Case Officer: Andrew Lewis

Applicant: Elgin Investments LLP

Proposal: Non-material amendment to 16/02446/F (Phase 9) - amended plans

Client:		
Site Address:	UPPER HEYFORD, PHASE 9 BICESTER	
Drawing Title:	HOUSE TYPE DL2v2 ELEVATIONS	
Scale:	Date drawn:	Drawn by:
1:50 @ A1	FEB 21	MJR
Project Number:	Drawing Number:	Revision:
727	HTDL2v2-09-07	C3
Status:	<b>CONSTRUCTION ISSUE</b>

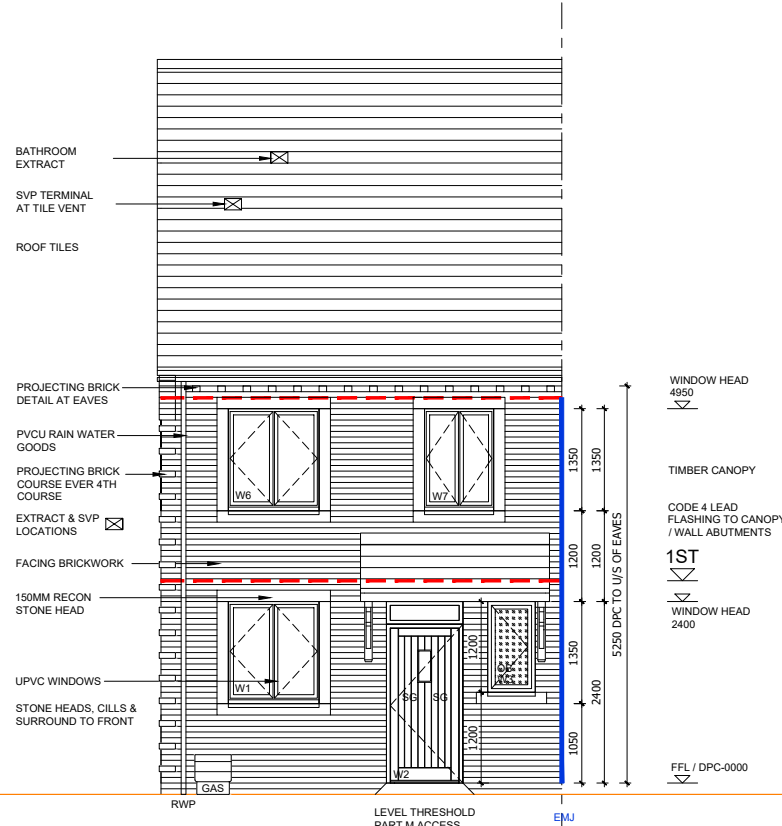
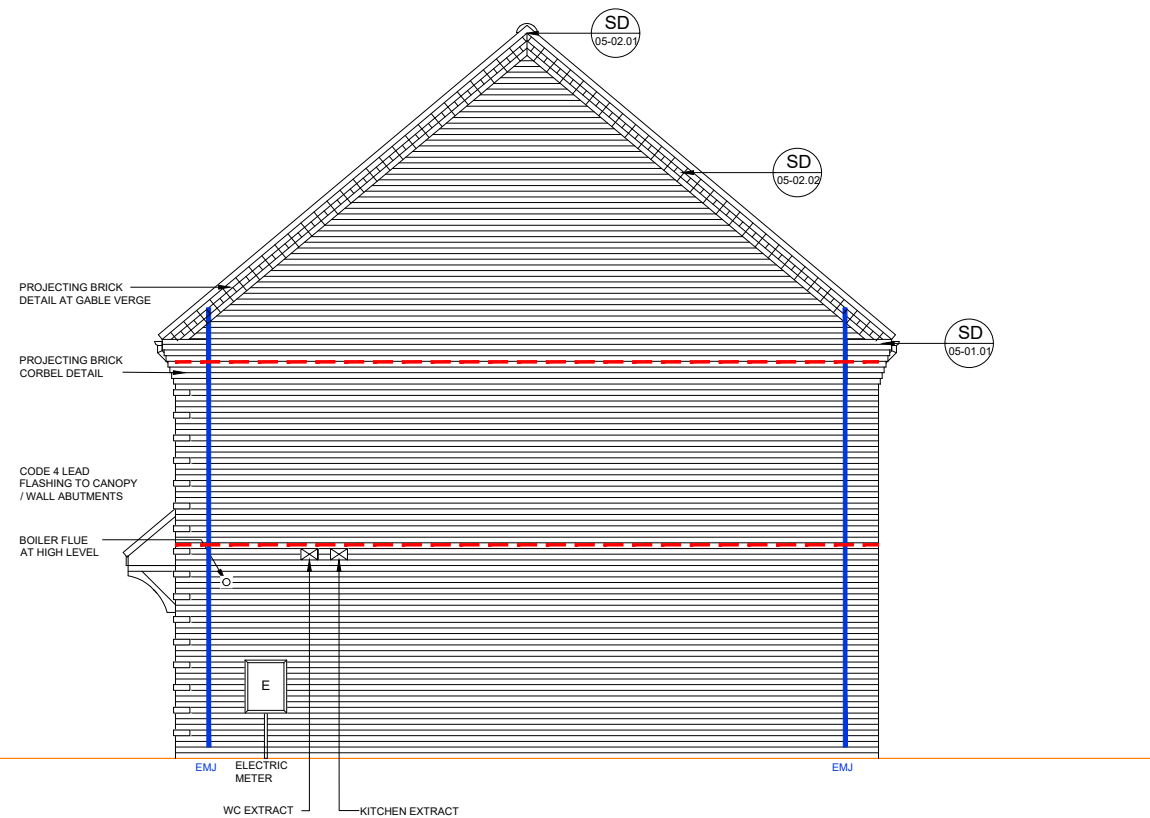
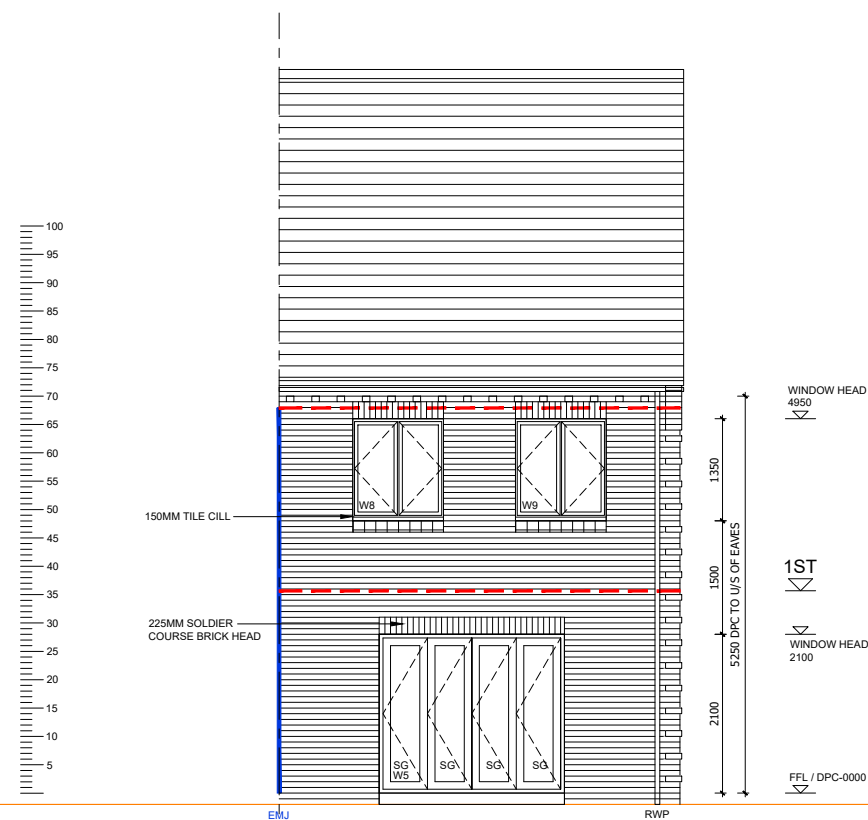
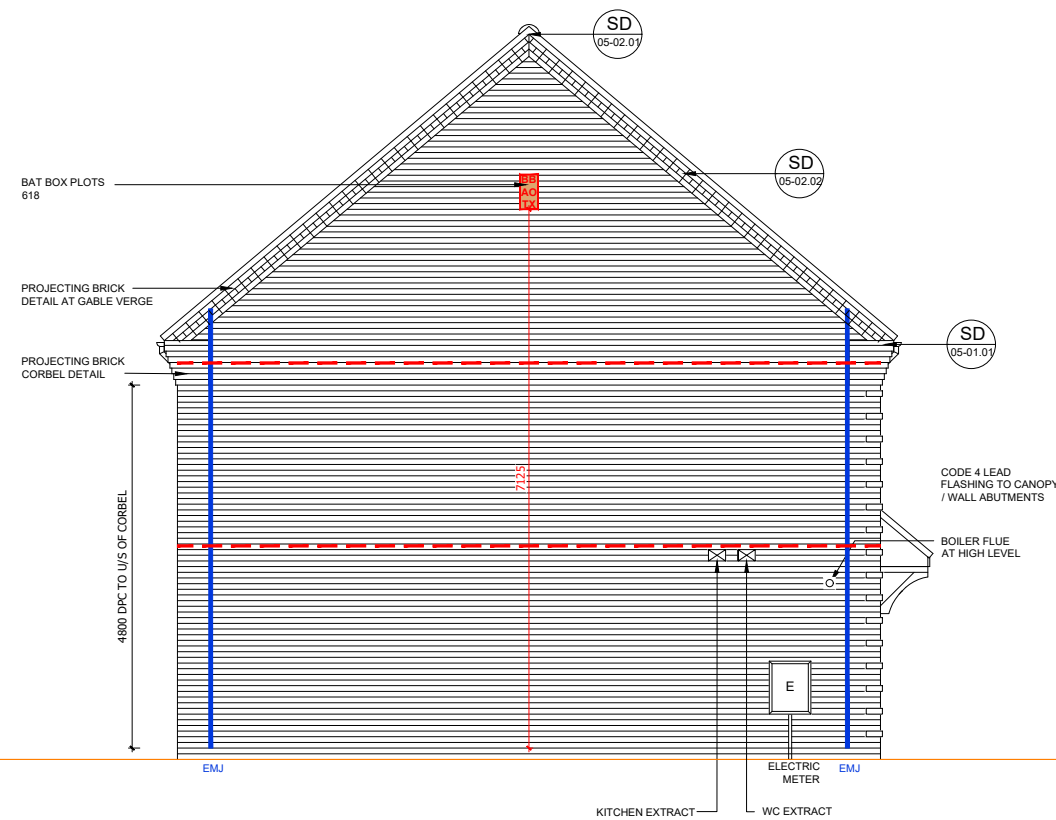
- DL2 design replaced by DL2v2 and elevational treatments updated to site location. Key elevations with stone detailing.

Drawing Title: HOUSE TYPE SP9
ELEVATIONS

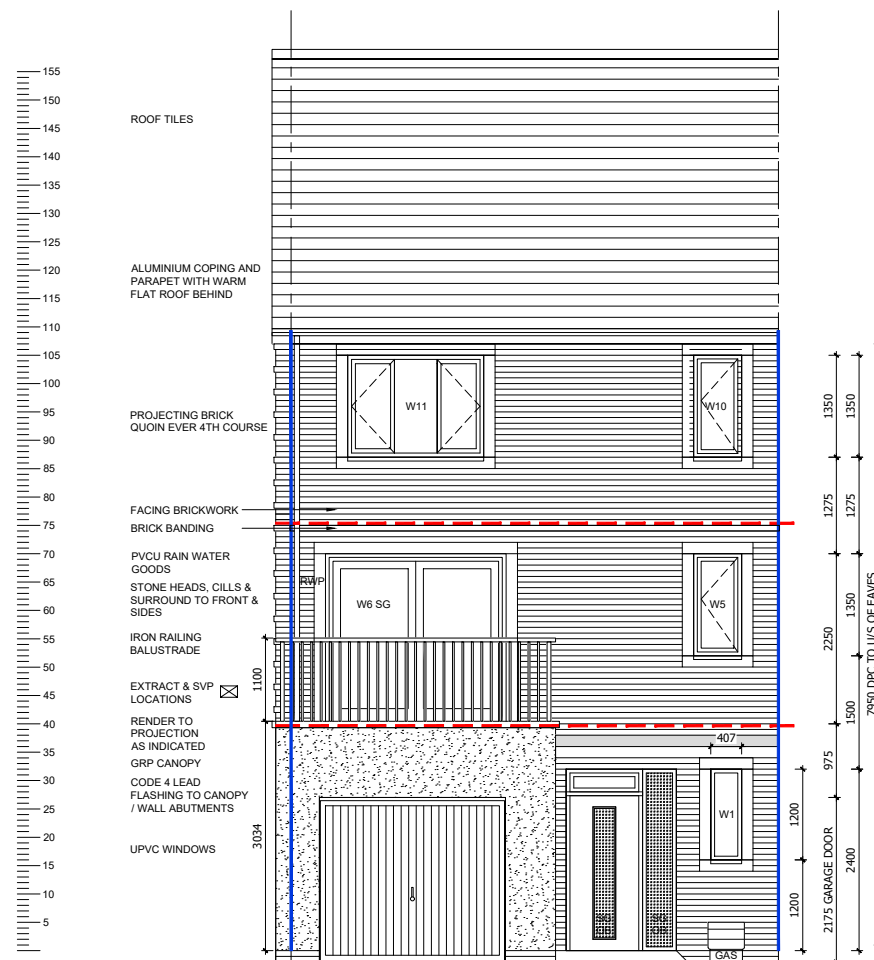
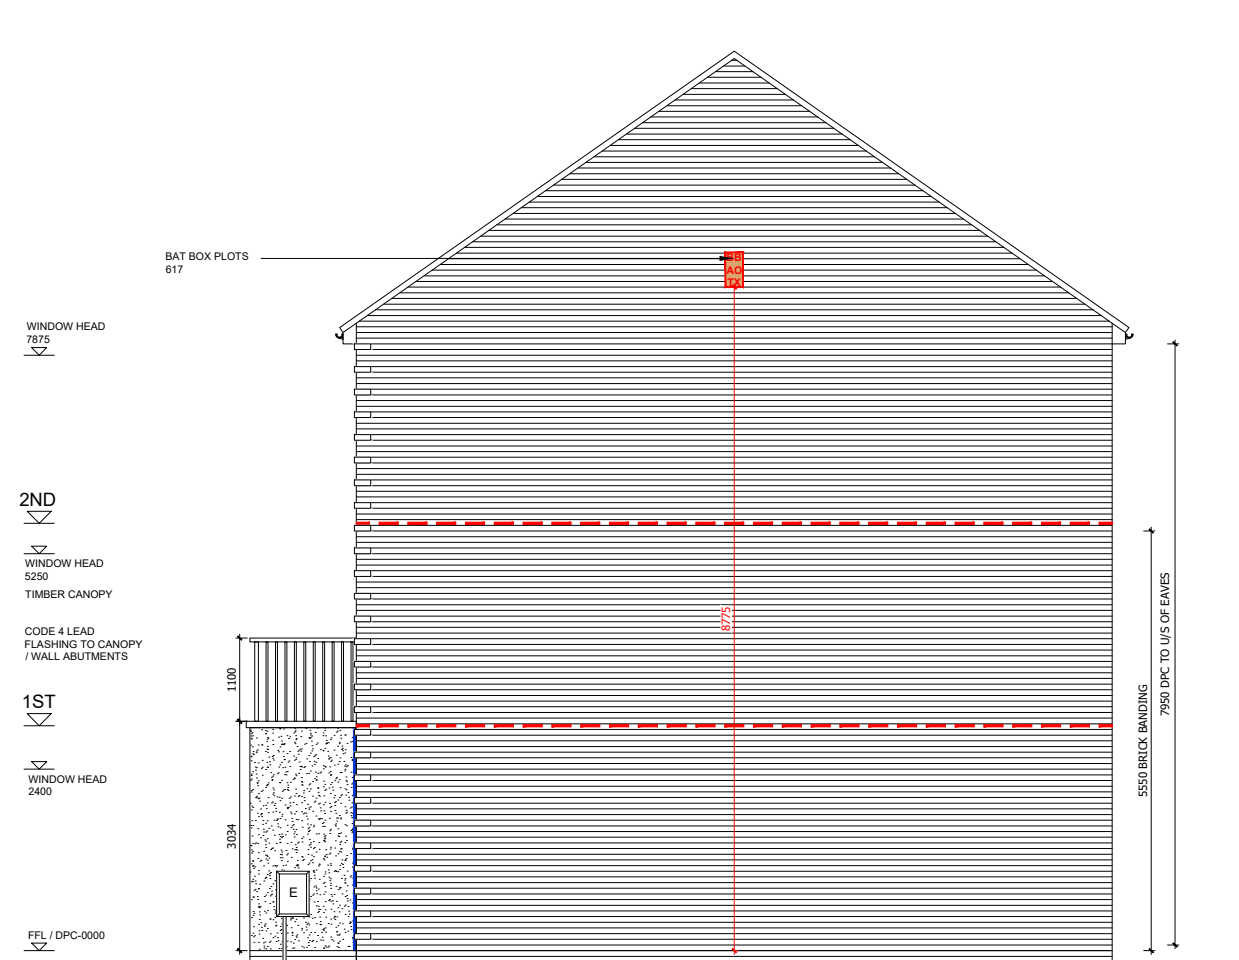
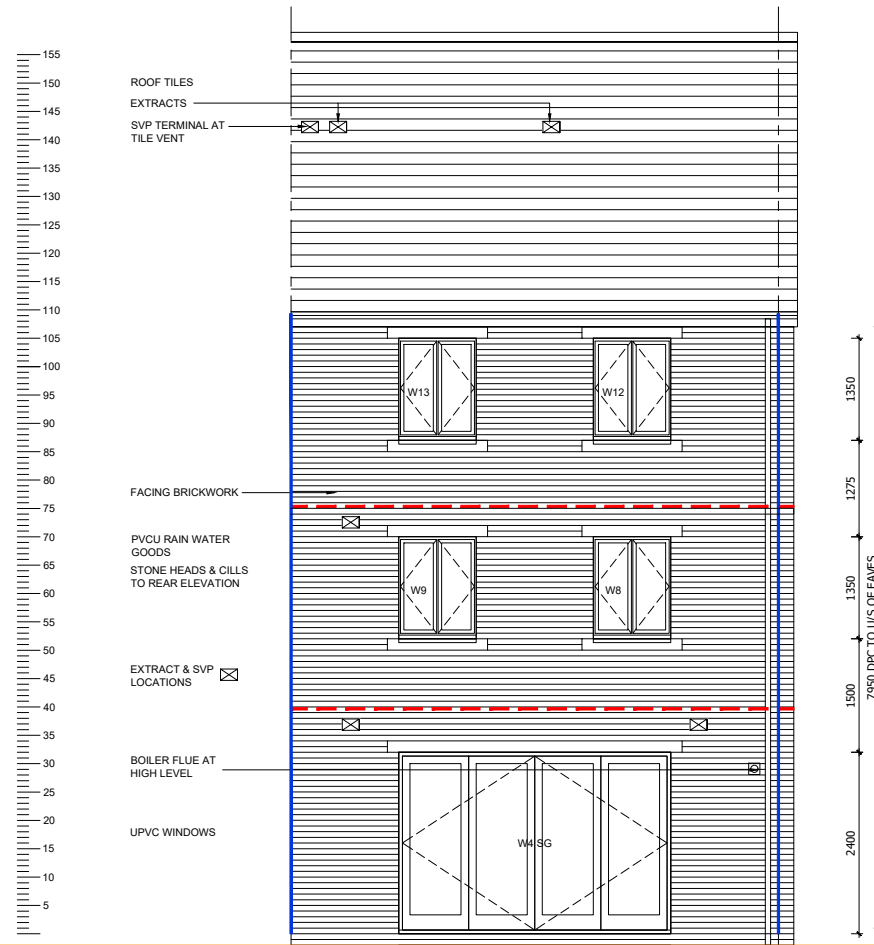
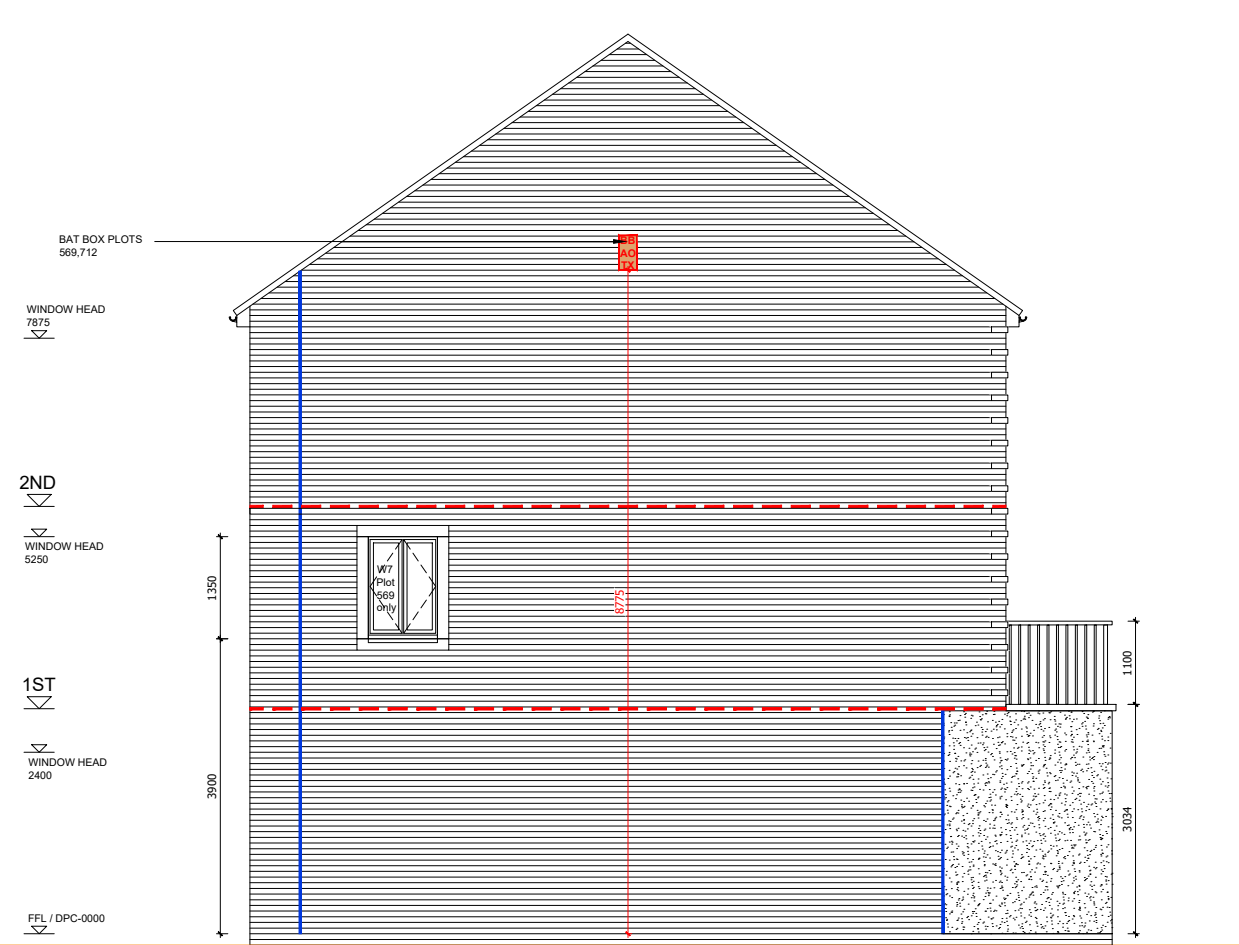
- SP9 floor plan amendments made based on a modified version of the phase 8b house type. First floor shower room cut back to WC to provide a more usable bedroom space, en-suite removed from 2nd floor and additional storage shared between bedroom 1 and 4. Elevation changed drastically from original preliminary

drawings including - dormer removal, change of roof profile and loss of chimneys, windows to the side have also been removed to deal with the notional boundary Part B issue that was raised by building control.
